Jeremy Bach
3410 Wilson Creek Road
Ellensburg, Wa 98926

I am adding these comments to the record regarding the 3BR custom cuts slaughterhouse/feedlot project, which is being proposed again in a residential neighborhood on Wilson Creek Road.

COMMENTS ON (REVISED) SEPA APPLICATION

**3BR CUSTOM CUTS  
PROCESSING PLANT**

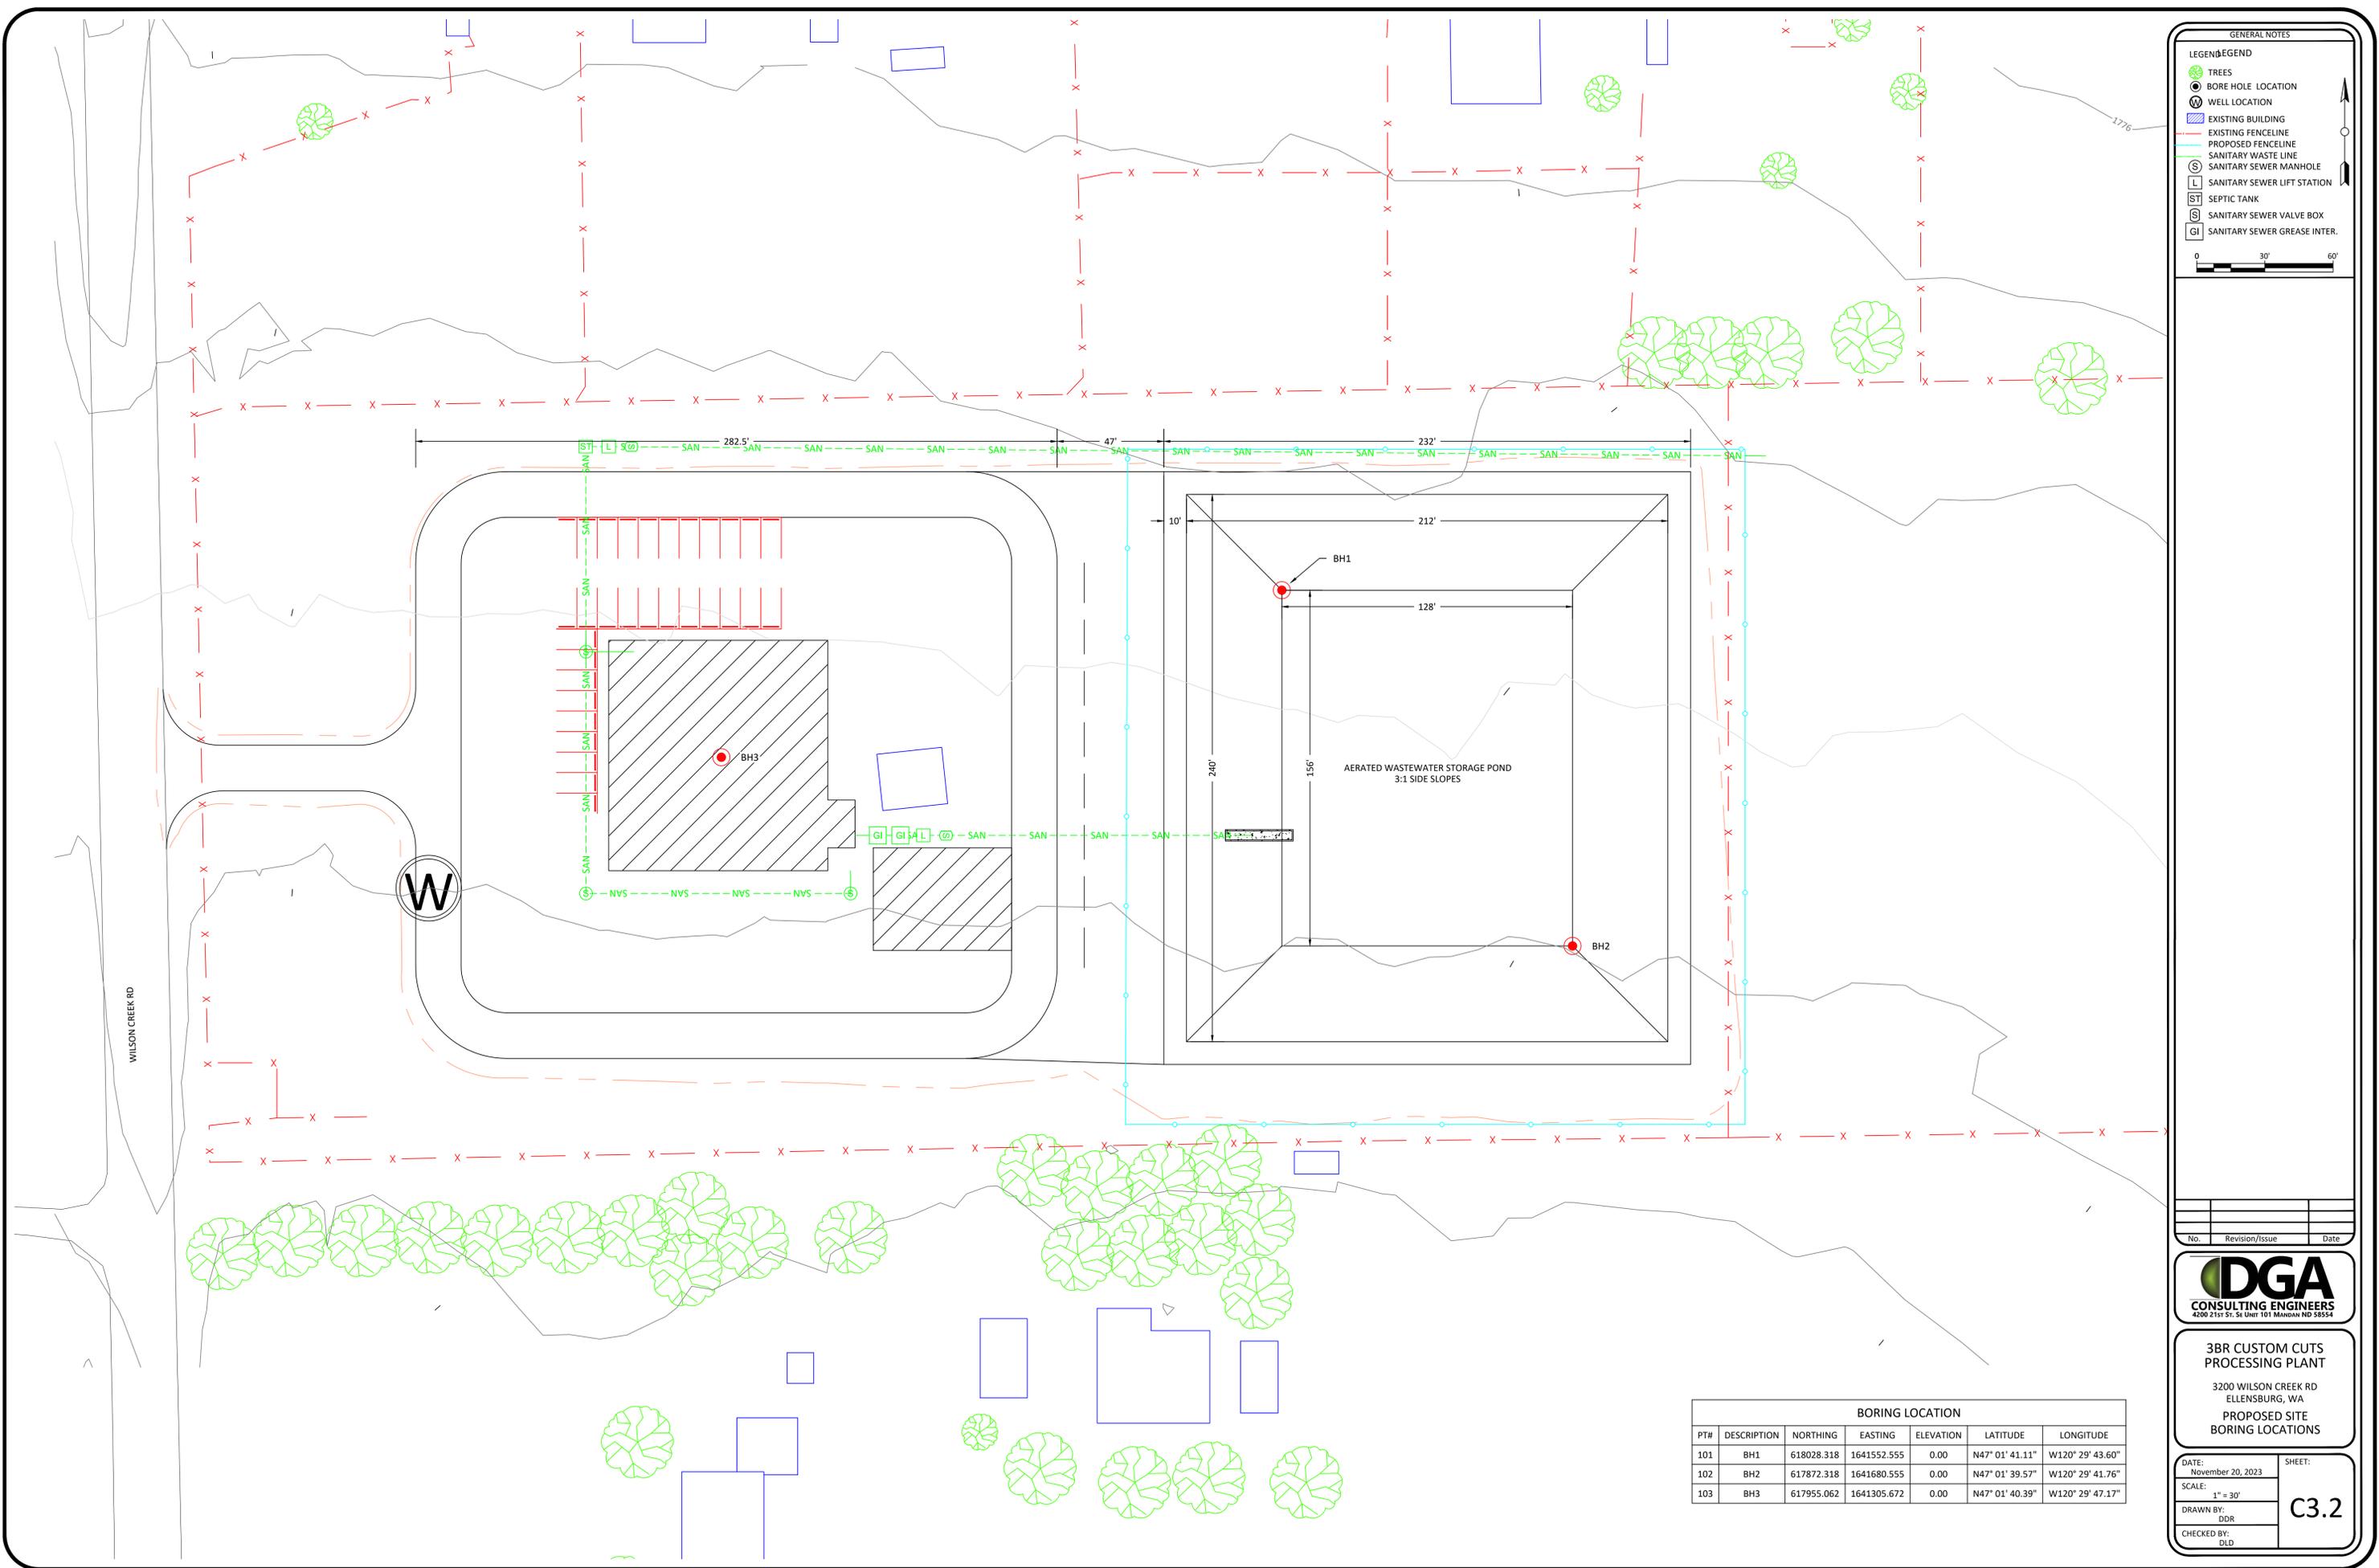
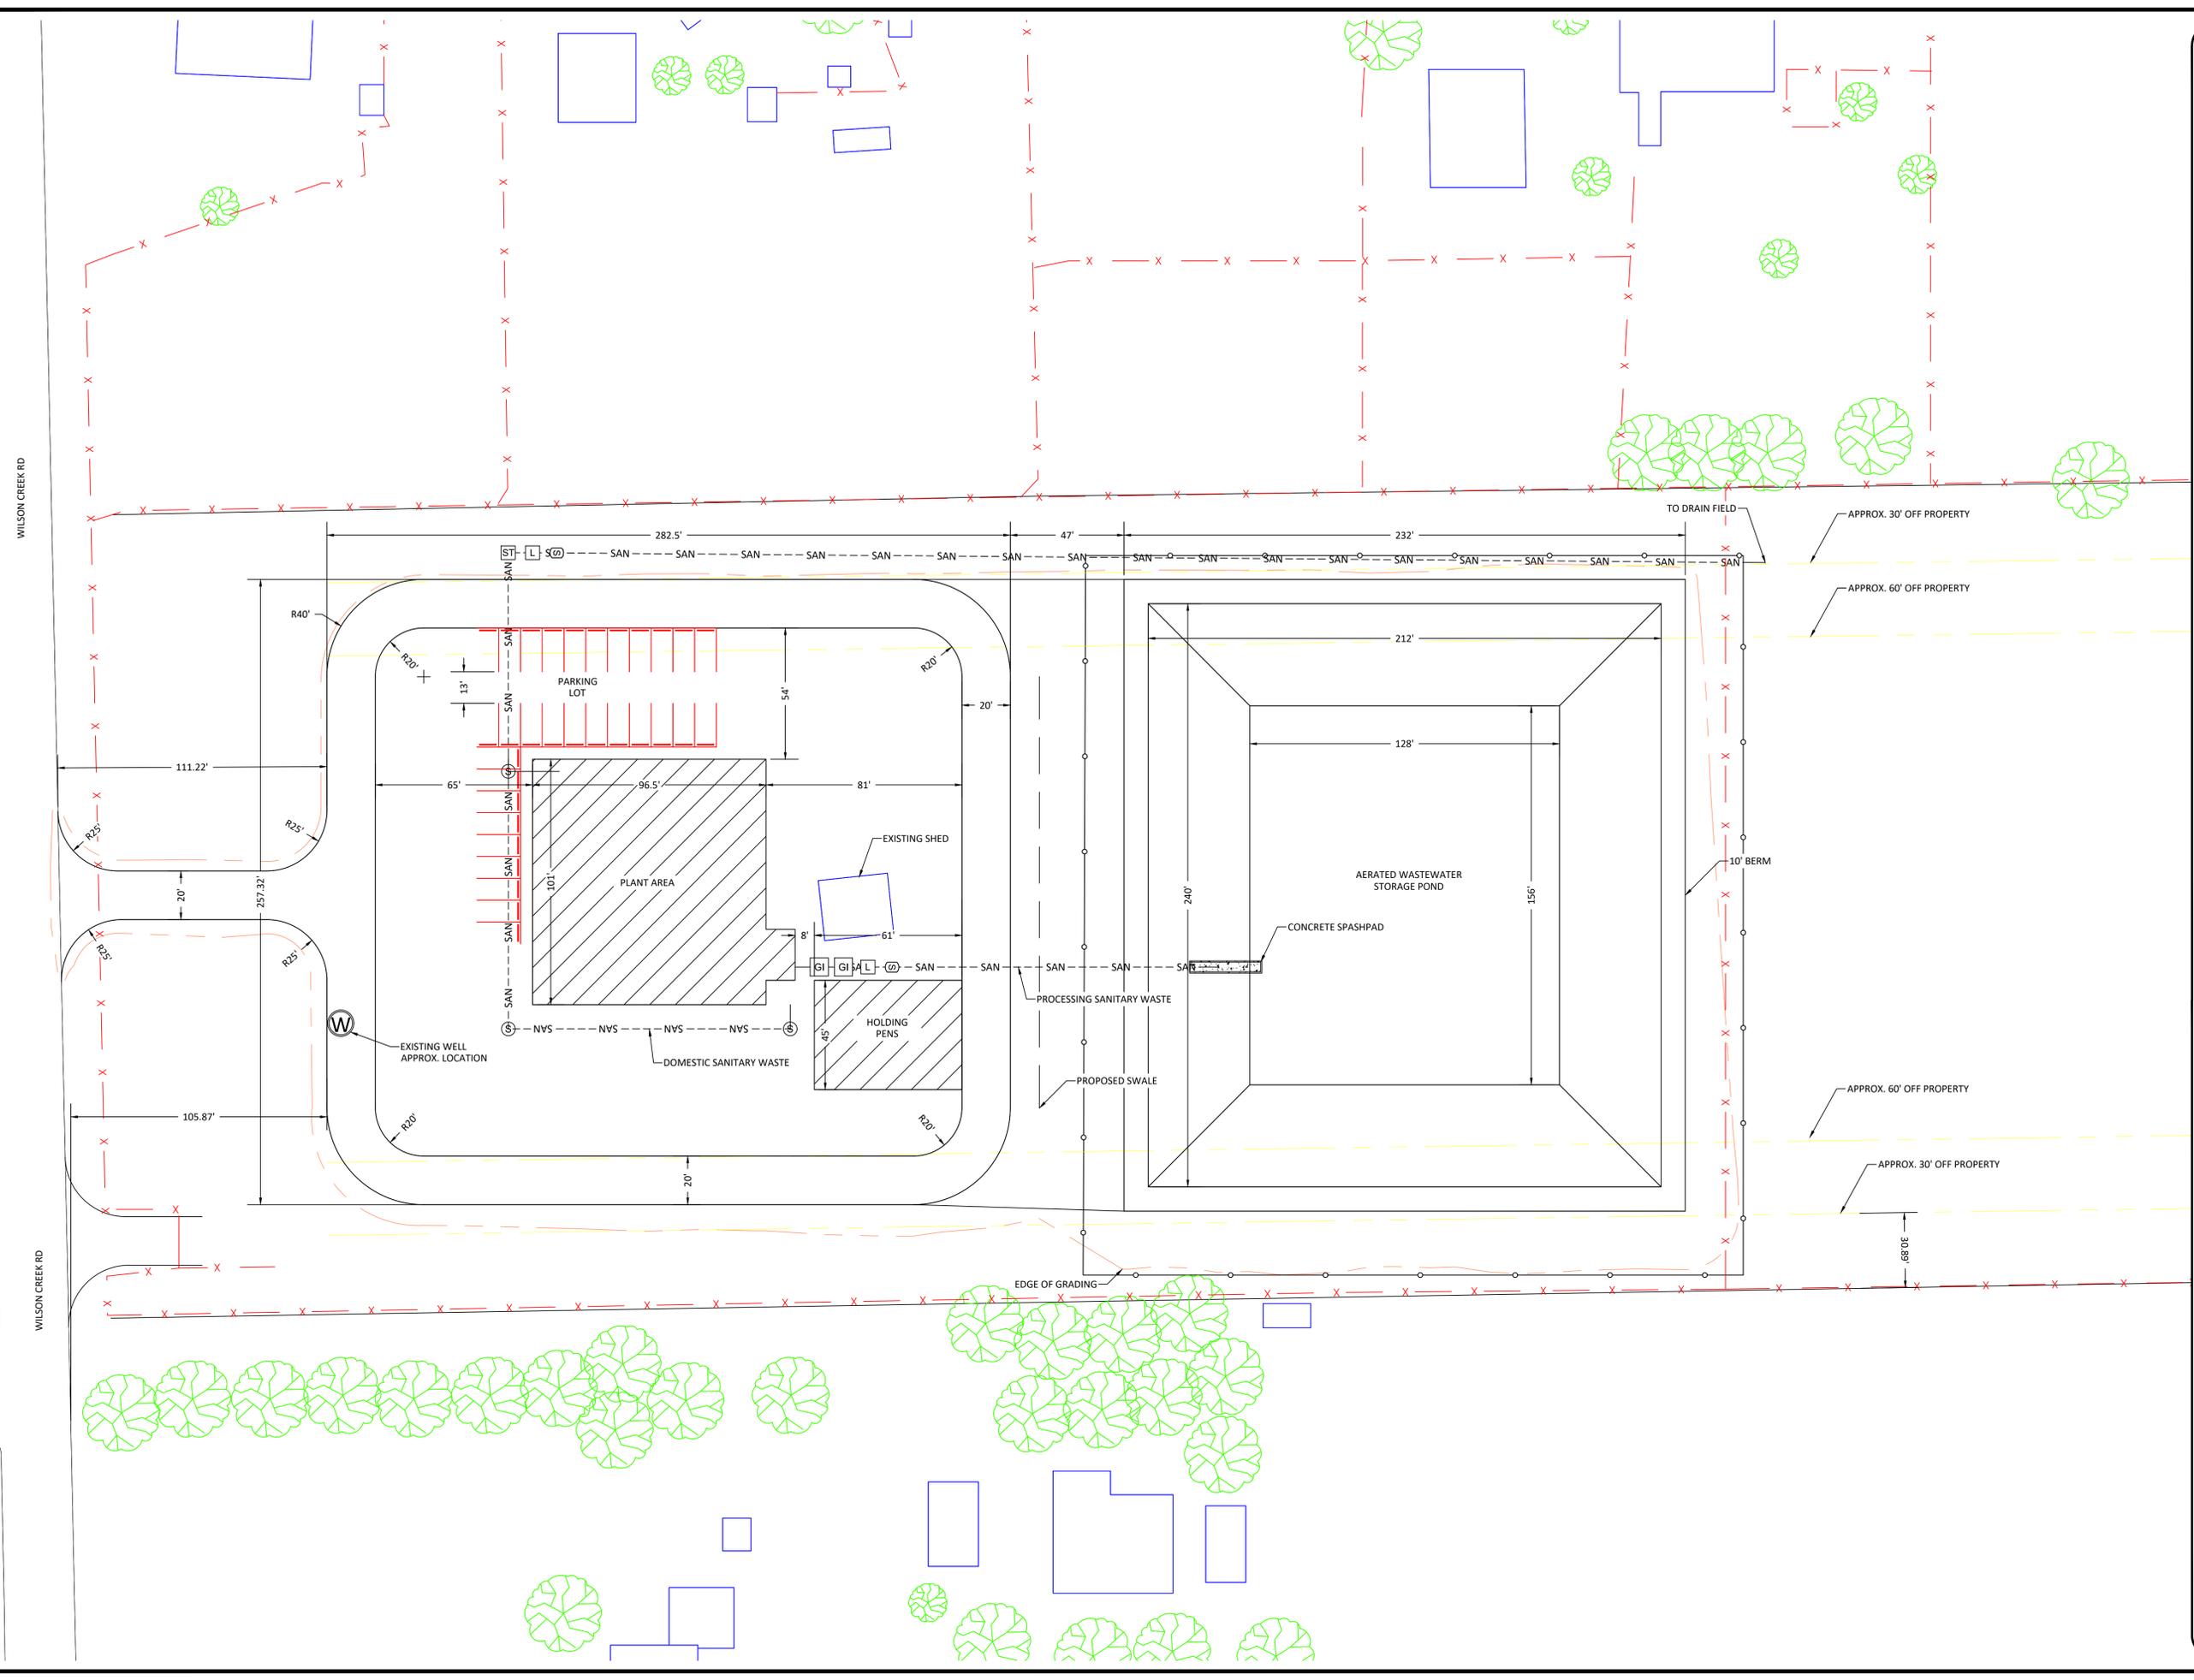
The current location of the existing well that would be used as a community well is located in or by the public access road as per the applicants' drawings submitted for comment on November 29, 2023.

Community wells need to have a 100ft radius in all directions as a sanitary area, this existing well does not, it is also located in an area that floods every spring as documented in my public comments from May 24, 2023.

The current site plan has the holding pens and facilities up gradient from the existing community well and flood area which are directly located within 150 ft of the Wilson Creek Road ditch.

Per the drawings, on November 29, 2023, it shows a 30-lot parking area. This parking lot is also located up gradient from the community well.

This large parking area is not even discussed in the SEPA application, and it does not outline how they are going to address the stormwater runoff created from this 30-car parking lot.
